From: [REDACTED]
Sent: 25 May 2023 11:58
To: Planning
Cc: [REDACTED]
Subject: Application 3/2023/0325 Land adjacent to 9 Old Road Chatburn
Attachments: 23_0325_Construction_Mgmt_Plan.pdf; 23_0325_Landscape_Strategy.pdf; 23_0325_Construction_Method_Statement.pdf; Application 3_2021_1153 - Comments 09.12.21.pdf; Planning Application 3_2022_0500 (Figure 1 added Rev.1).pdf

Please find below comments on the above Planning Application 3/2023/0325 Land adjacent to 9 Old Road Chatburn

Drawing file: planx_downloads / 23_0325_Construction_Mgmt_Plan.pdf

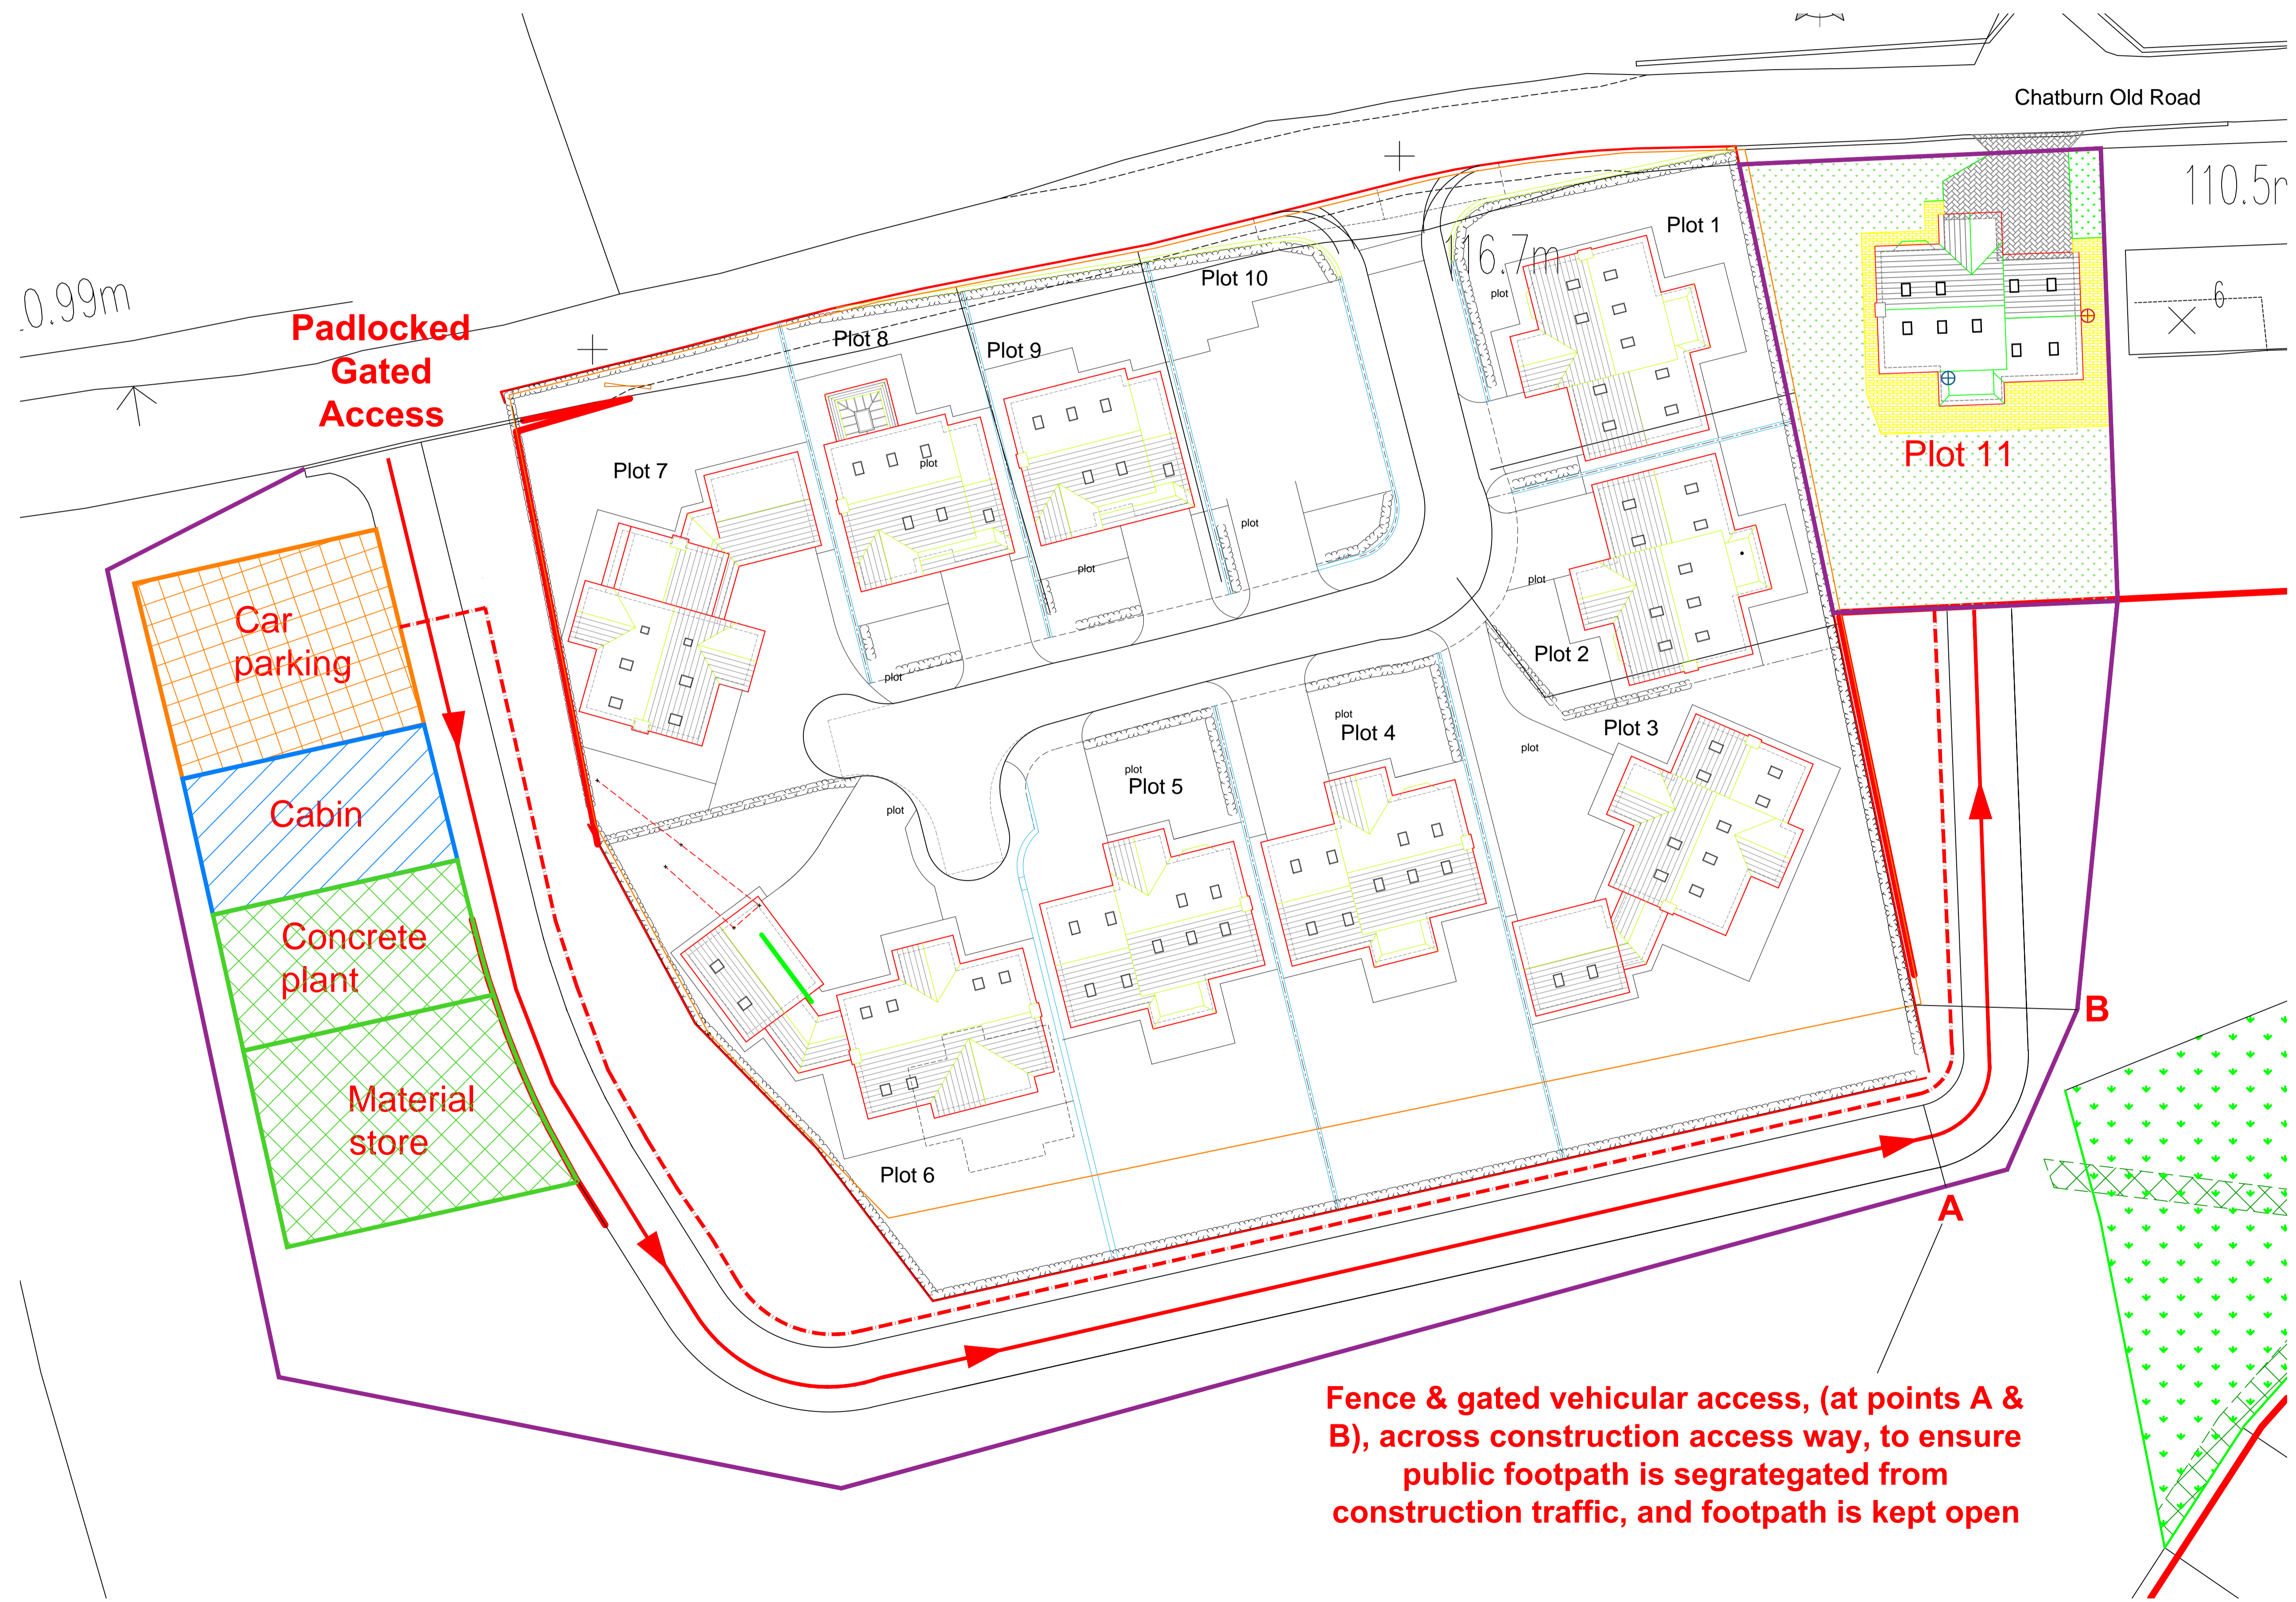
2. The proposed access route shown on the attached plan along the boundary of 3 (part),4,5,6,7 Hare Hill Croft (HHC) has already been constructed without planning permission.

3. The proposed compound shown on the attached plan lies on land that should have, by now, been reinstated back to its original condition, in line with the requirements of the HHC planning permission following the completion of HHC.

6. There are no levels on the attached plan that allow you to assess the scale of excavation required to get from current levels to the lower levels of the proposed dwelling. There would inevitably need to be a ramp from the access route as shown on the plan, in order get down to the lower levels and construct the proposed dwelling.

7. The access route is shown as one-way on the plan, see comment on reversing below.
8. The landscape plan shows shrubs along land that does not belong to the developer along the boundary for No.2 HHC, plus there is a c.5m drop in levels between the edge of the landscaping width along the HHC boundary and the proposed dwelling.

9. If permission is granted the gates either side of the footpath shown on the plan need to be locked when not in use as public could access the working area.
